13 December 2022

Our Ref: 2022/762784

**SSD-26876801 - The New Forest High School (New educational establishment)**

drawing title
CIVIL SITEWORKS AND STORMWATER PLAN - SHEET 1

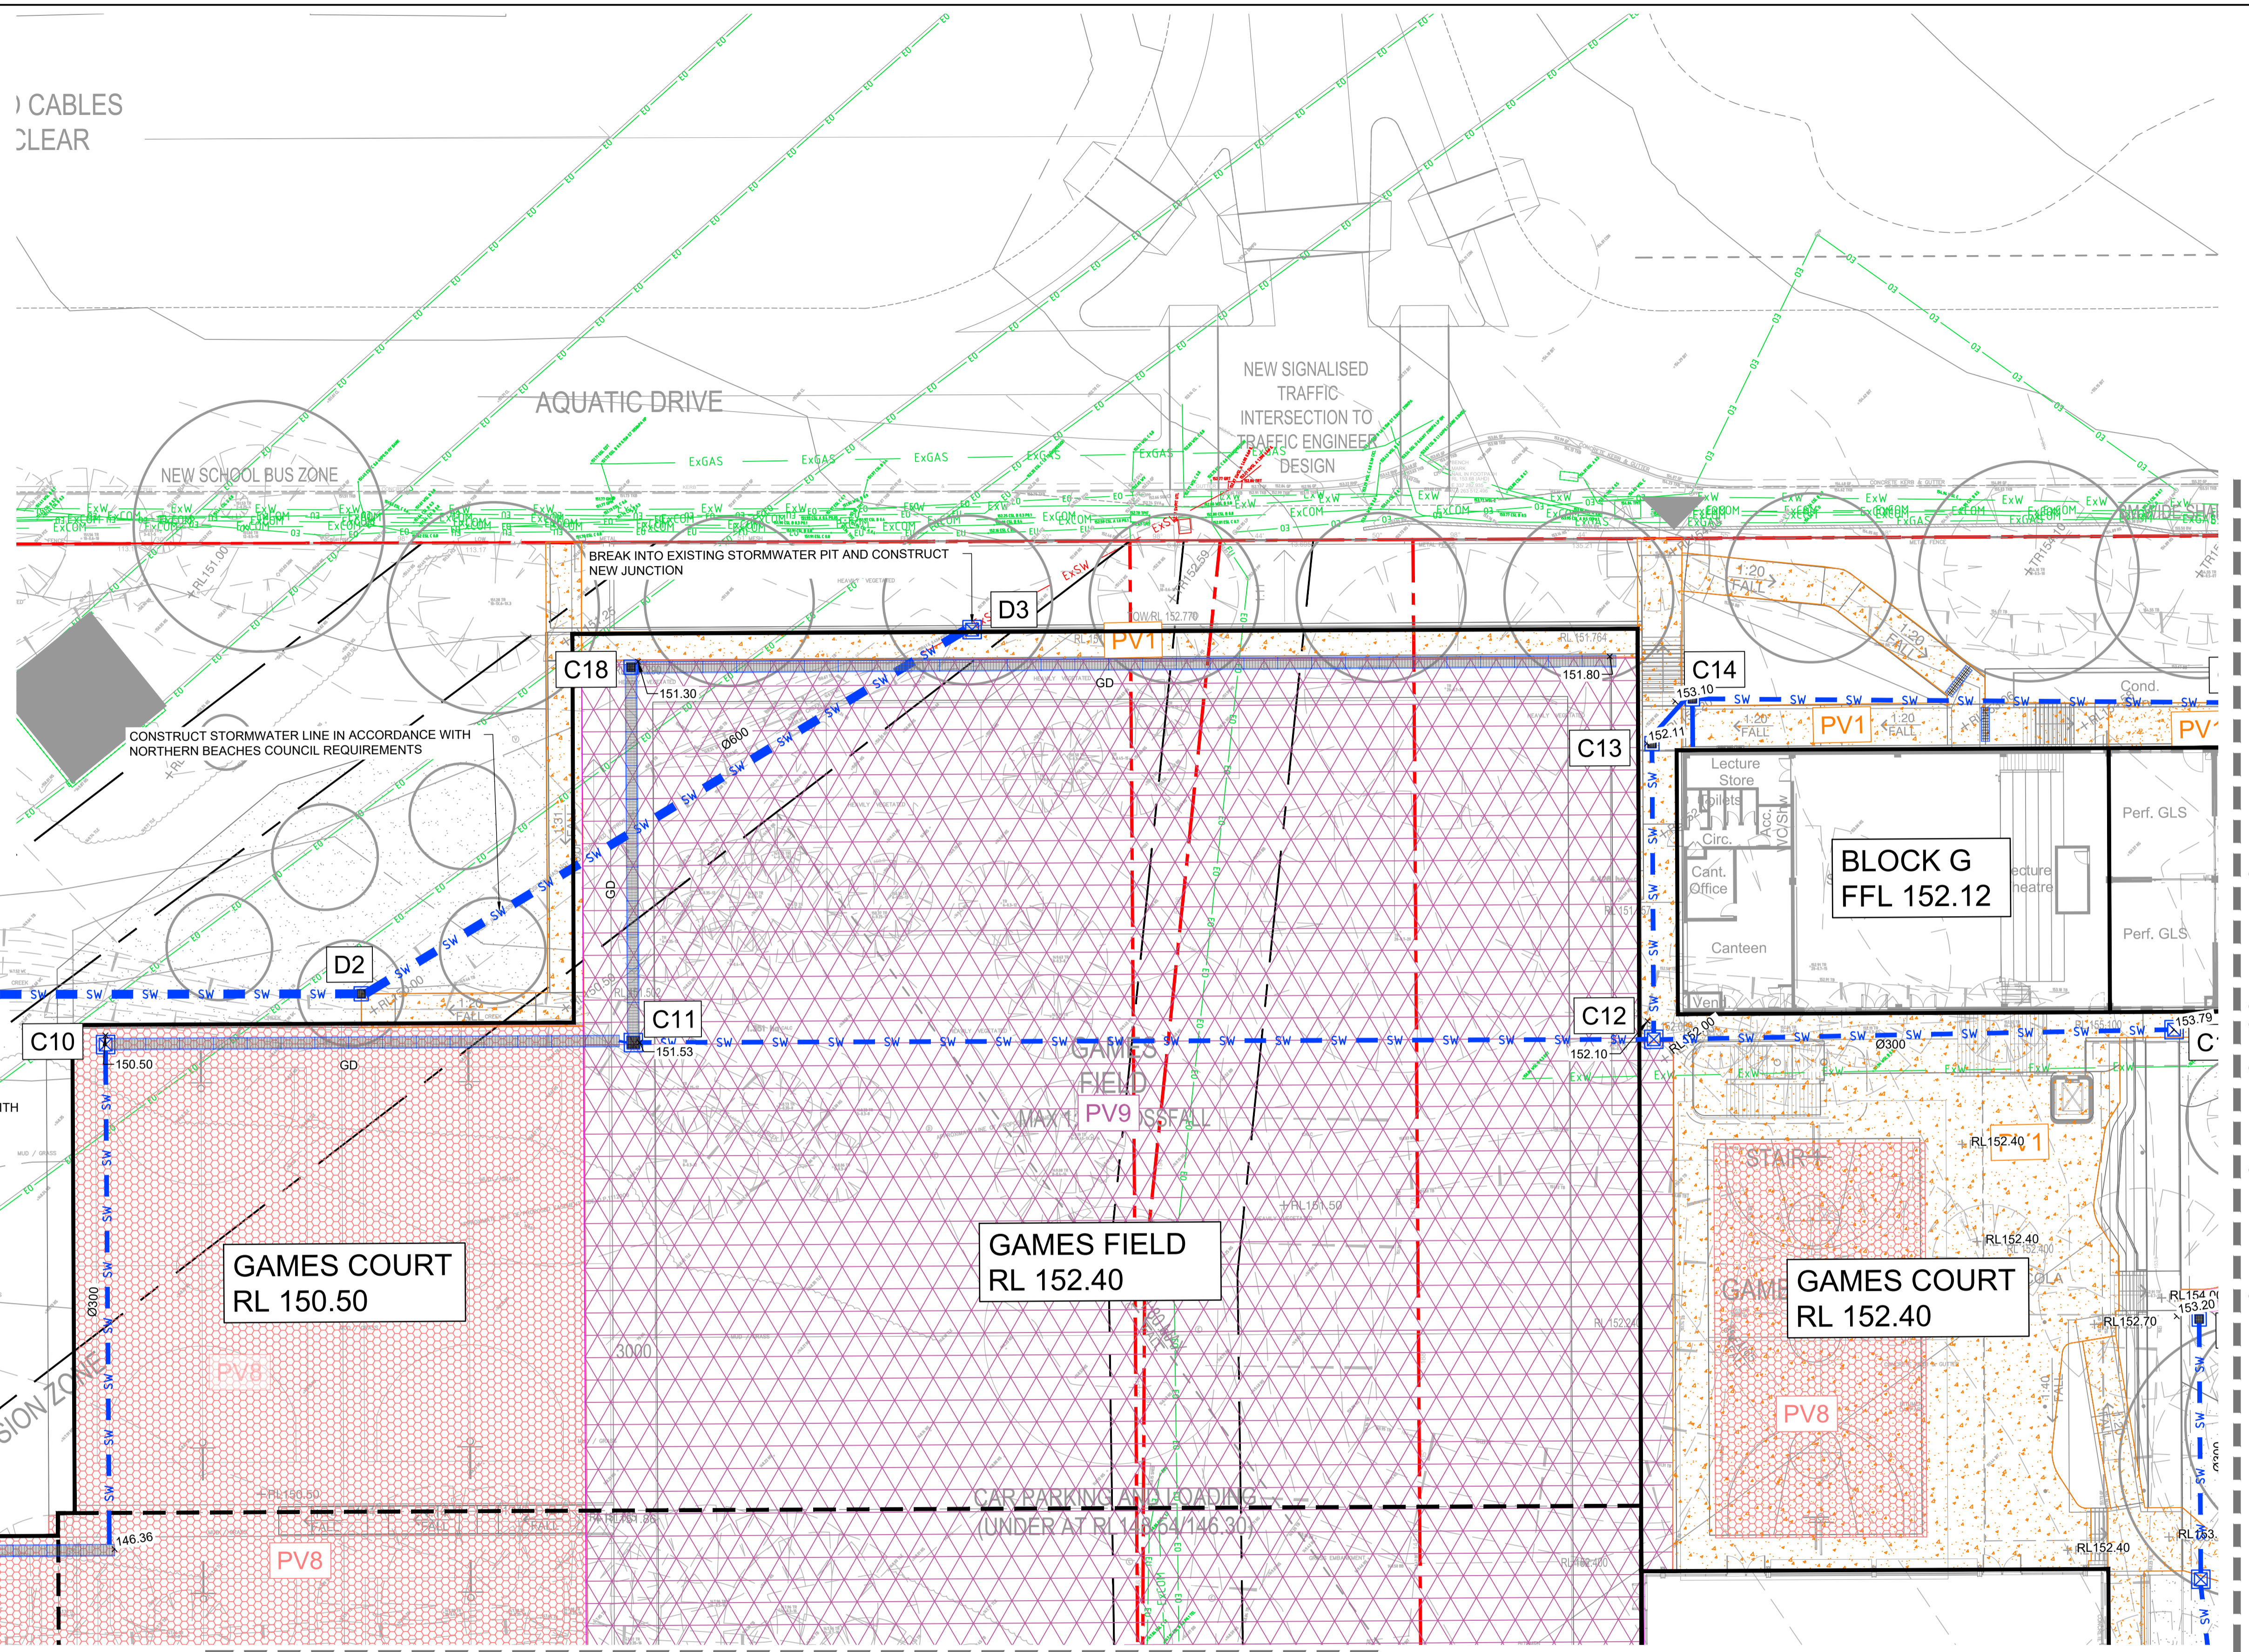
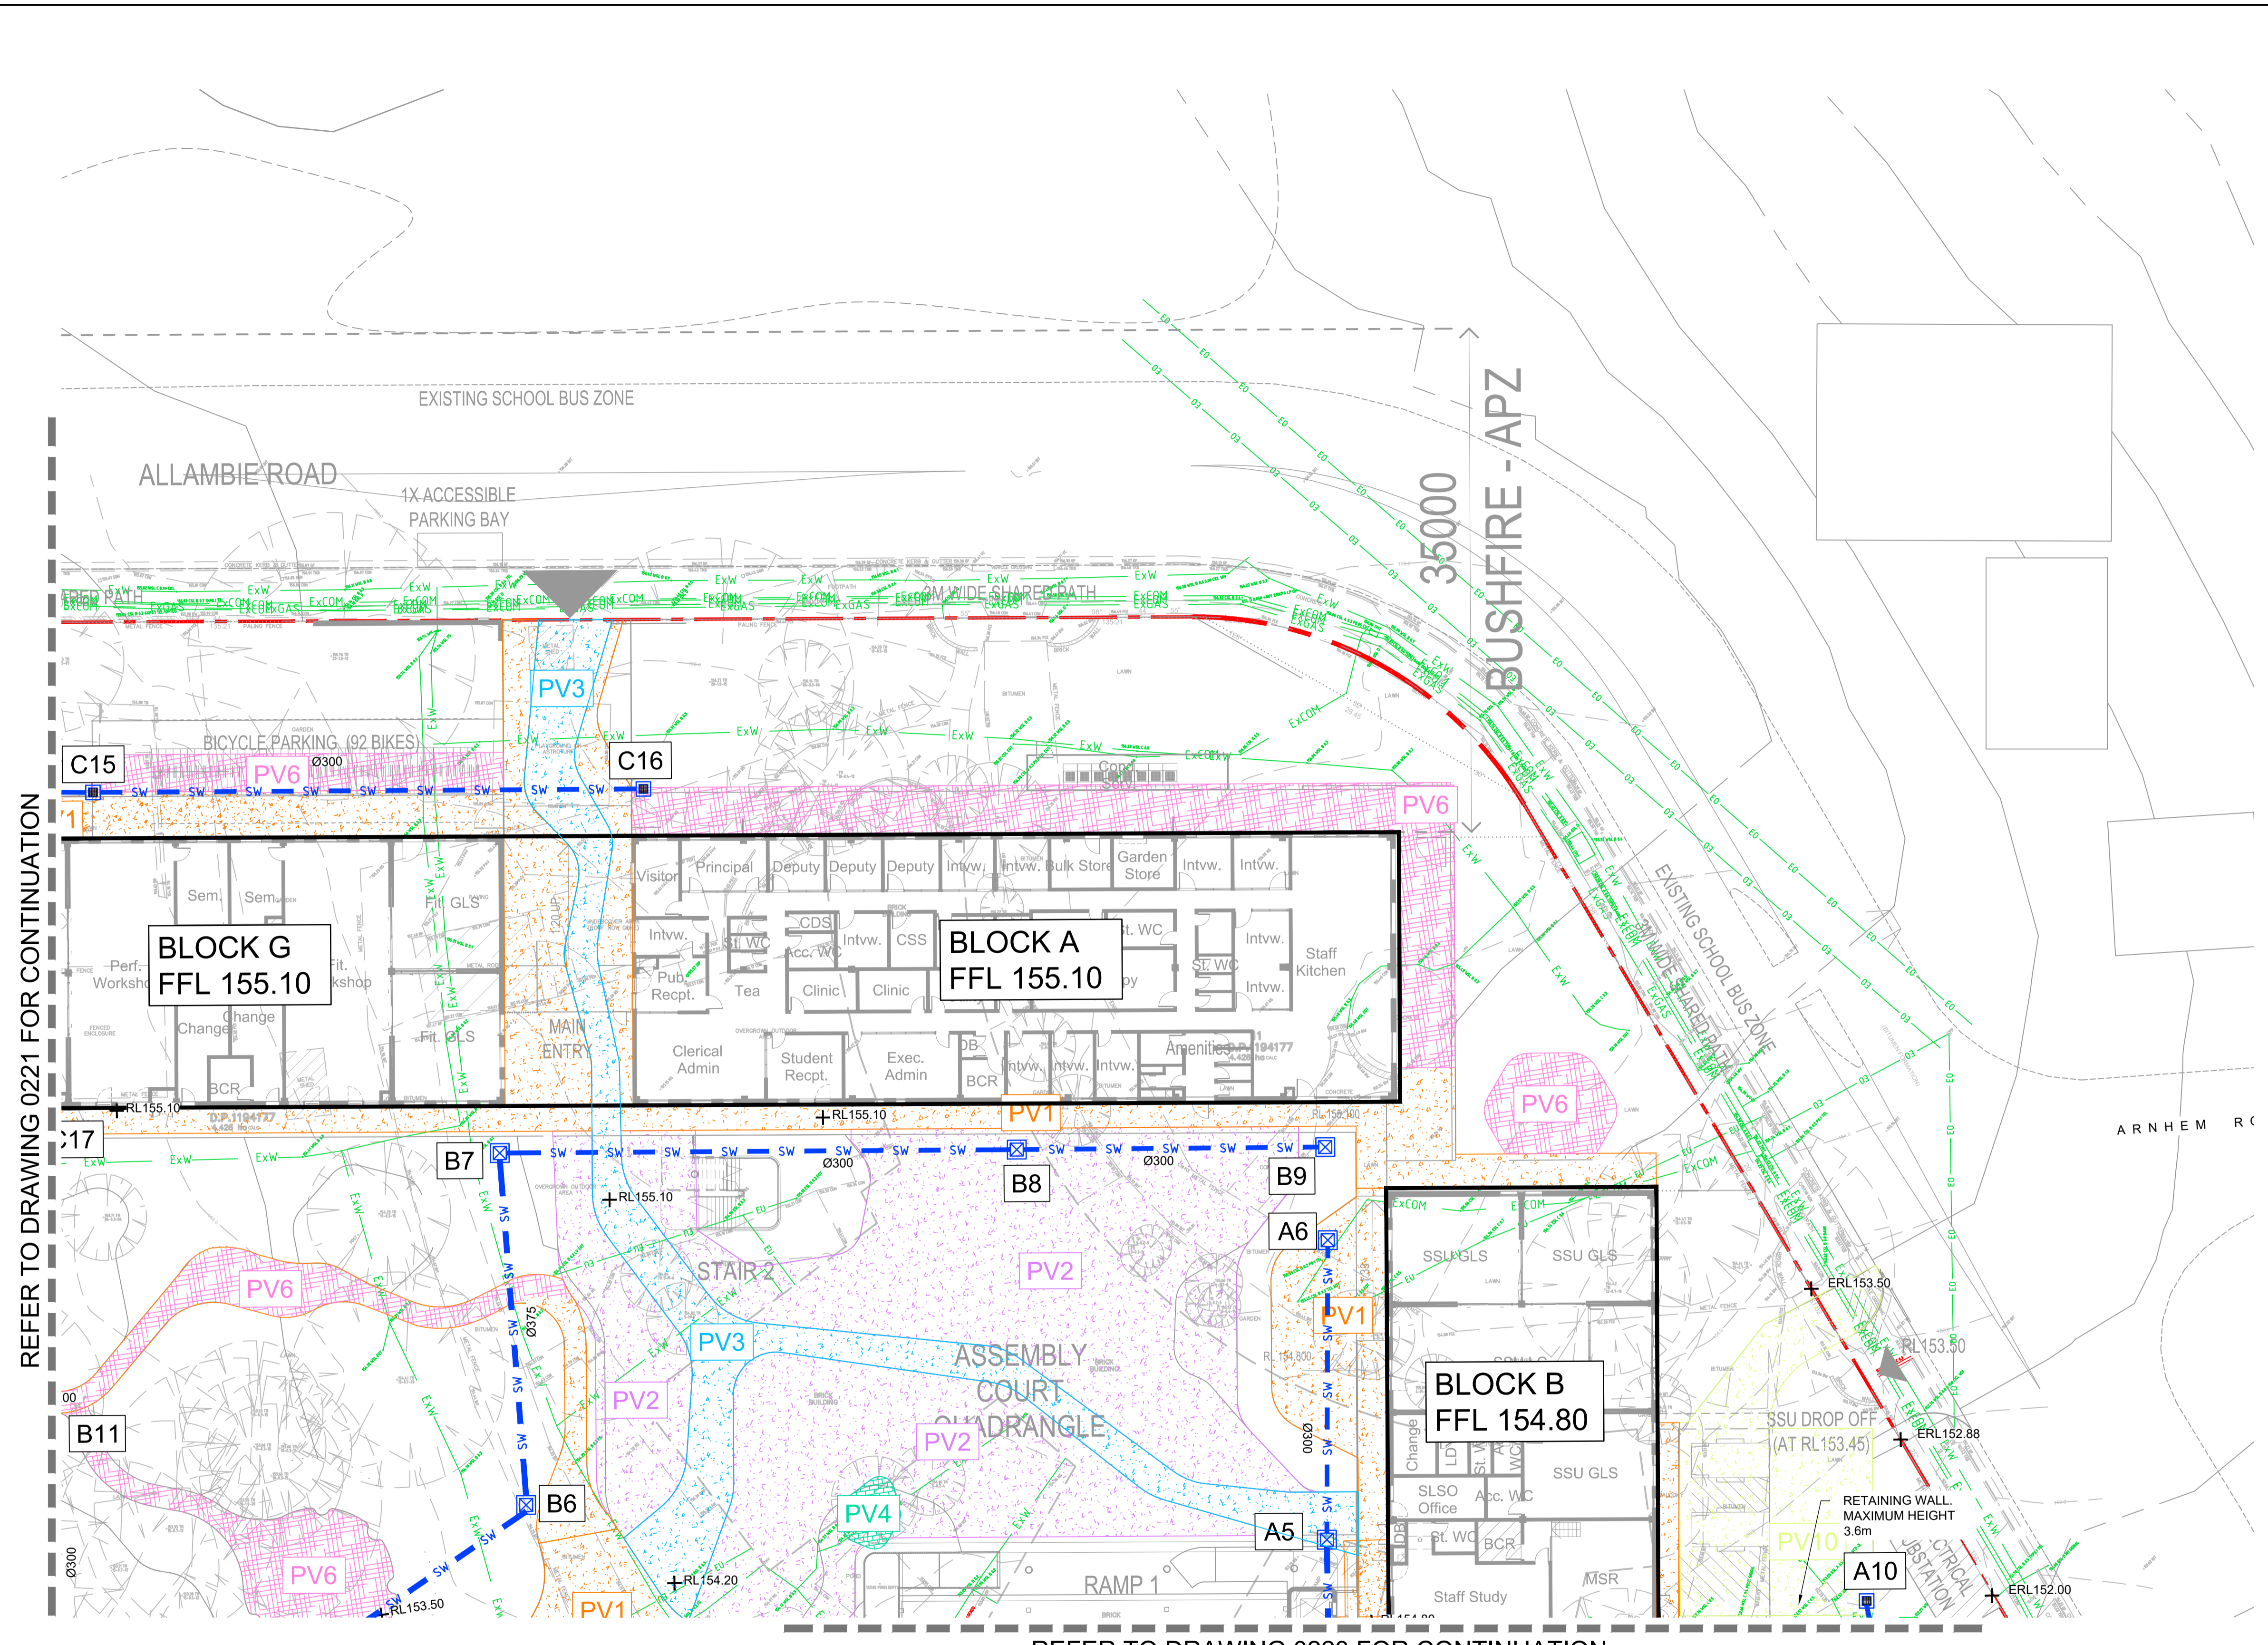
The stormwater drainage plans detail the extension of councils existing pit and pipe system from aquatic Drive with a 600mm RCP line. There appears to be a conflict with the extension of this line with a site drainage line which will runs over this line. The engineering consultant is to confirm whether there is a conflict and adjust the internal stormwater line location to avoid any potential conflict.
